Arun District Council
Arun Civic Centre
Maltravers Road
Littlehampton
West Sussex BN17 5LF
Planning & Building Control General Enquiries
Tel: (01903) 737756 Fax: (01903) 730442
Dx: 57406 Littlehampton
Minicom: 01903 732765
e-mail: planning@arun.gov.uk
website: www.arun.gov.uk/planning

Application No: WA/93/20/PL
Site Address: Land East of Tye Lane Walberton BN18 0LU
Description of works: Alternative vehicular access off Tye Lane & emergency access off Avisford Park Road, along with minor highway works following WA/95/18/RES. This site is in CIL Zone 2 (Zero Rated) as other development.

Thank you for your internet representation made on 14th May 2021 which has been recorded as an objection with the comments as follows:

Appendix B
Traffic Flow Diagrams

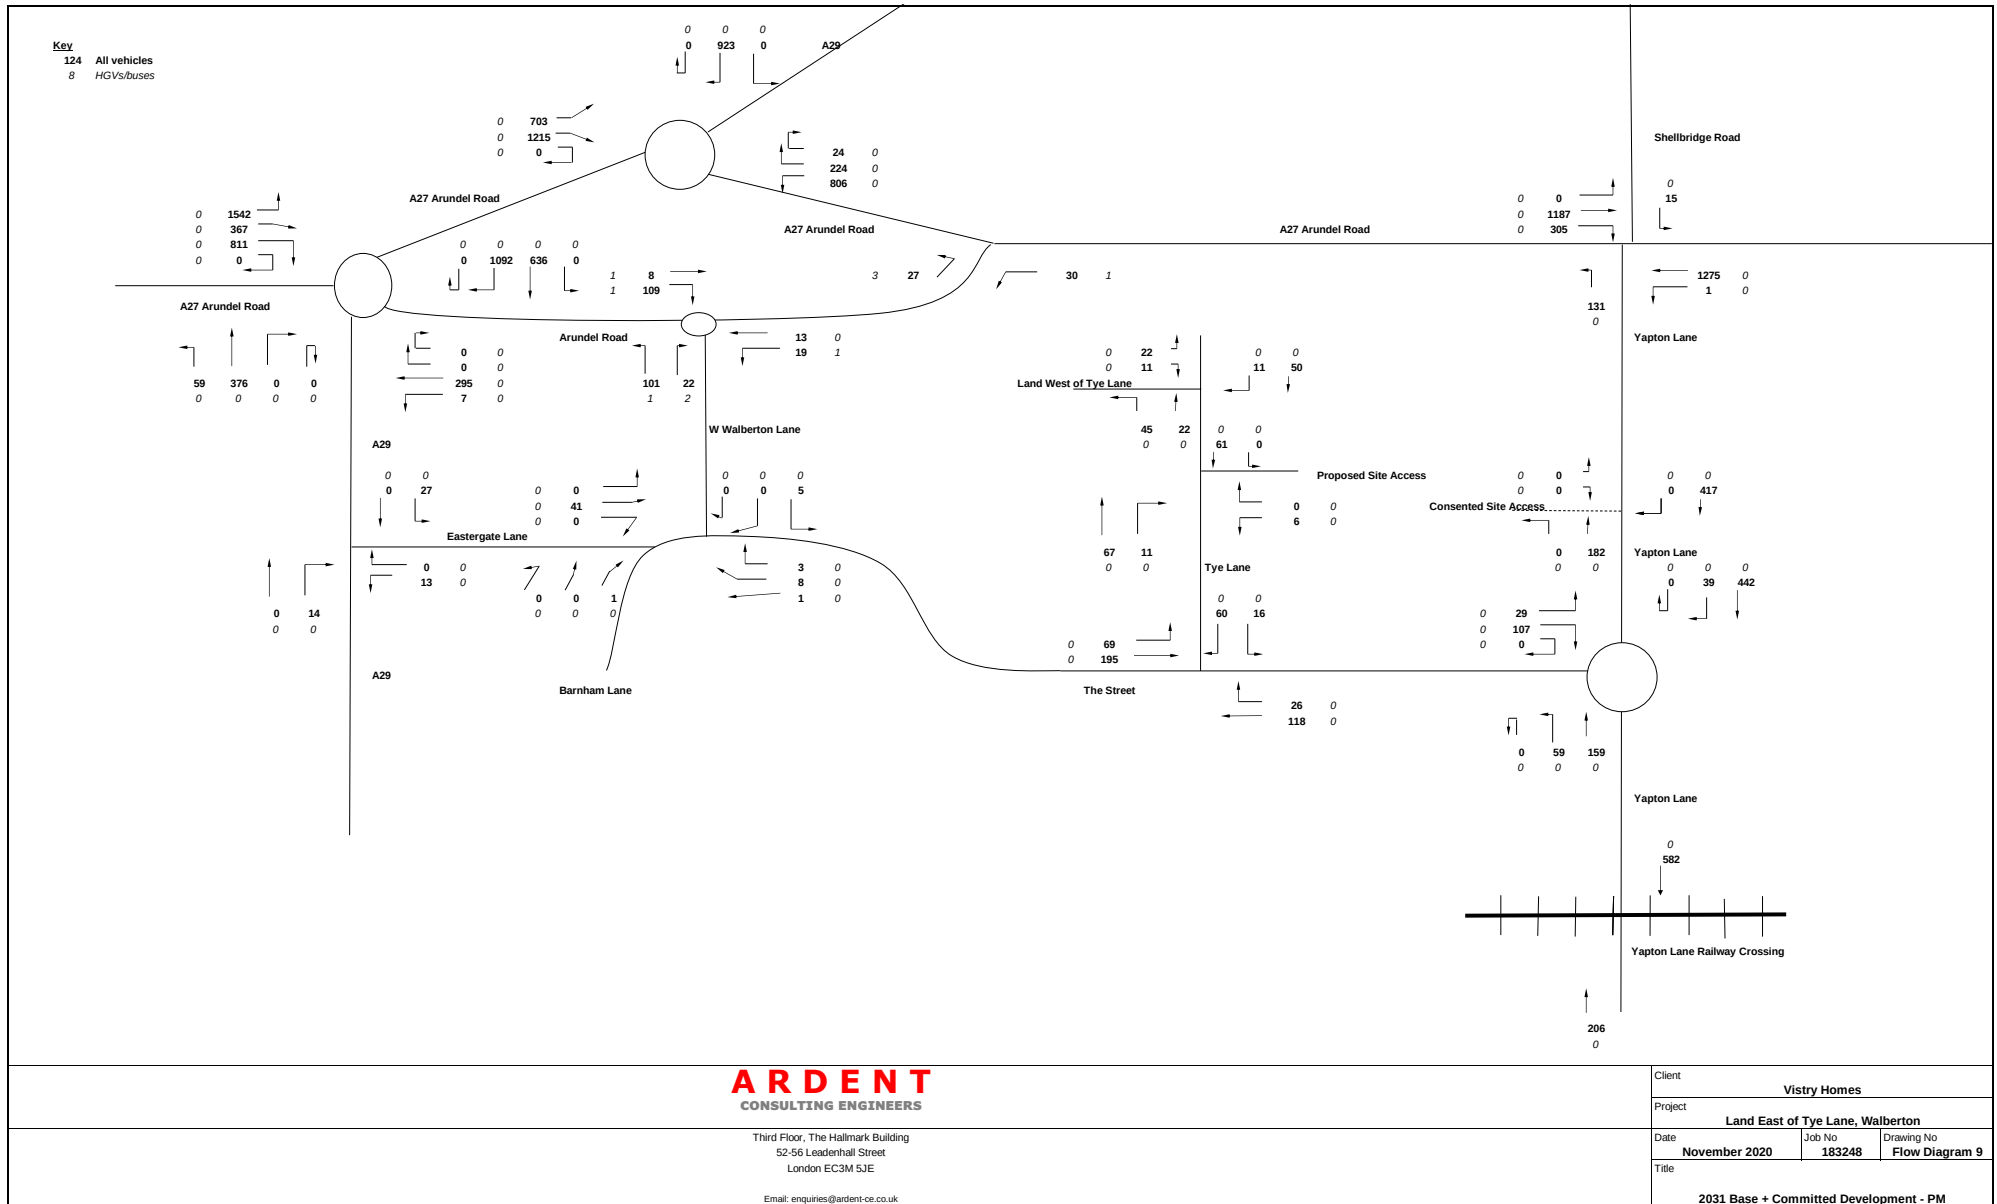
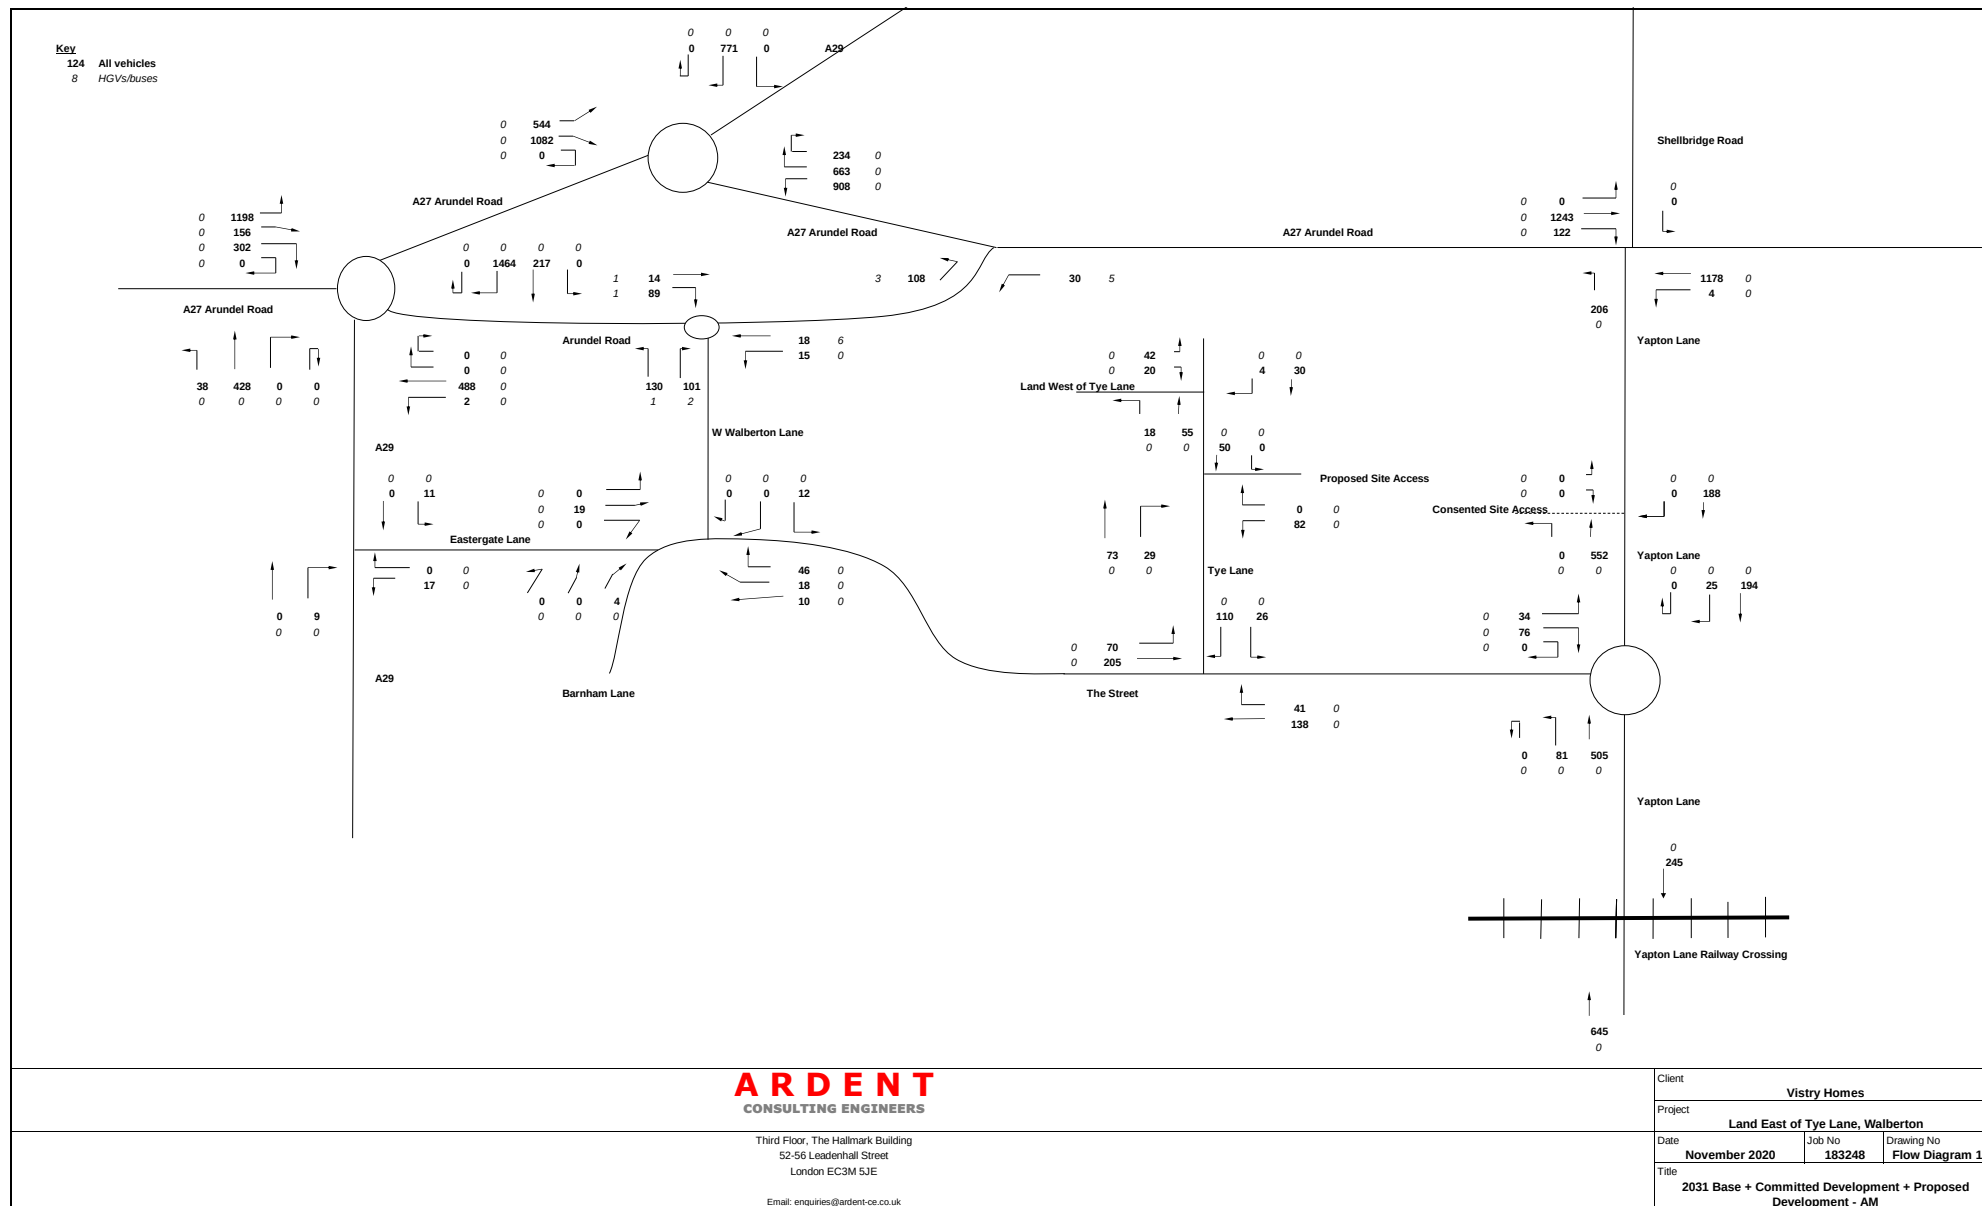
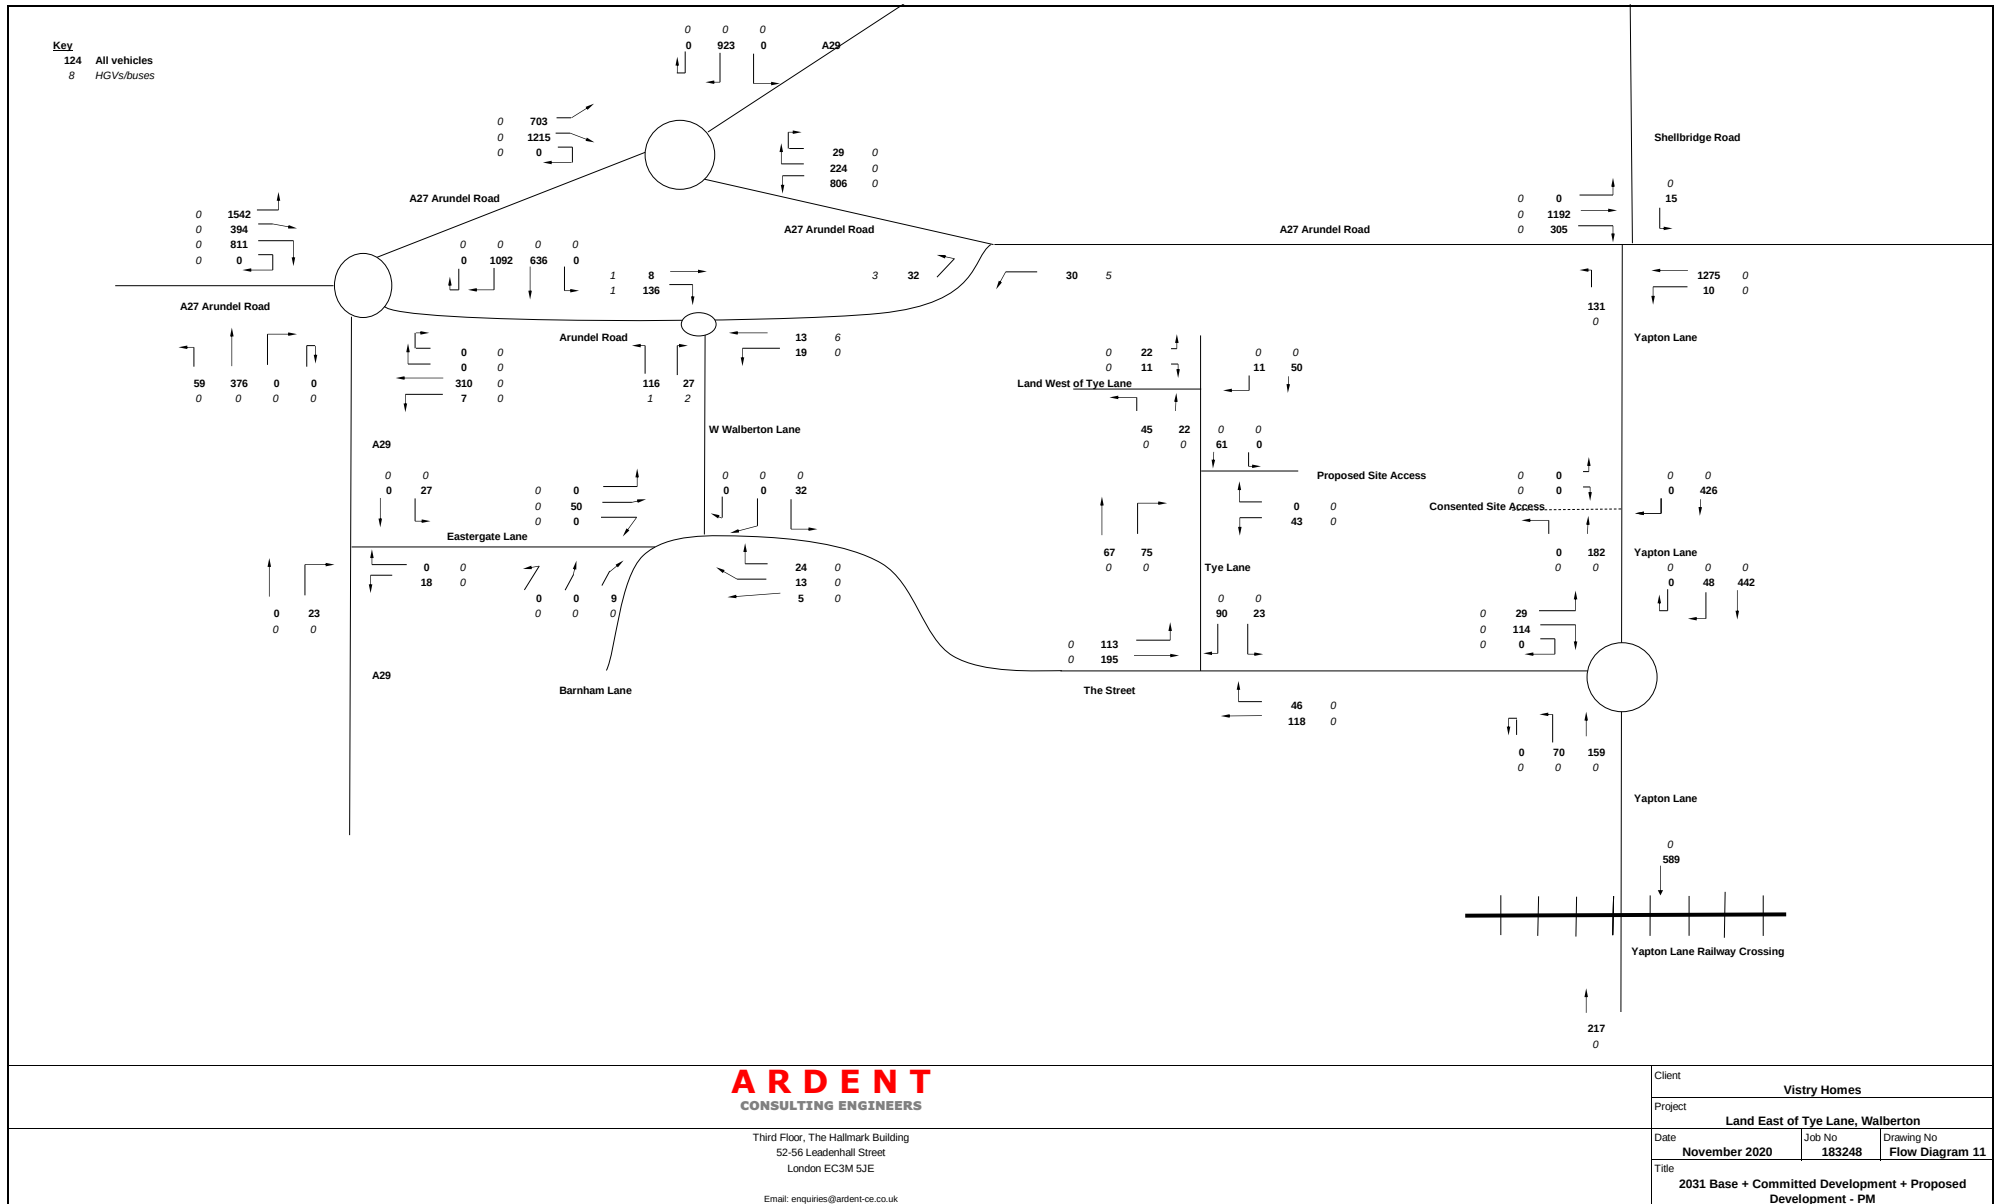
A number of Traffic Flow Diagrams are provided to illustrate changes in traffic flow patterns. However, they seem to have incorrect data. It is not clear whether the application is based on Tye Lane being open or closed at the A27.
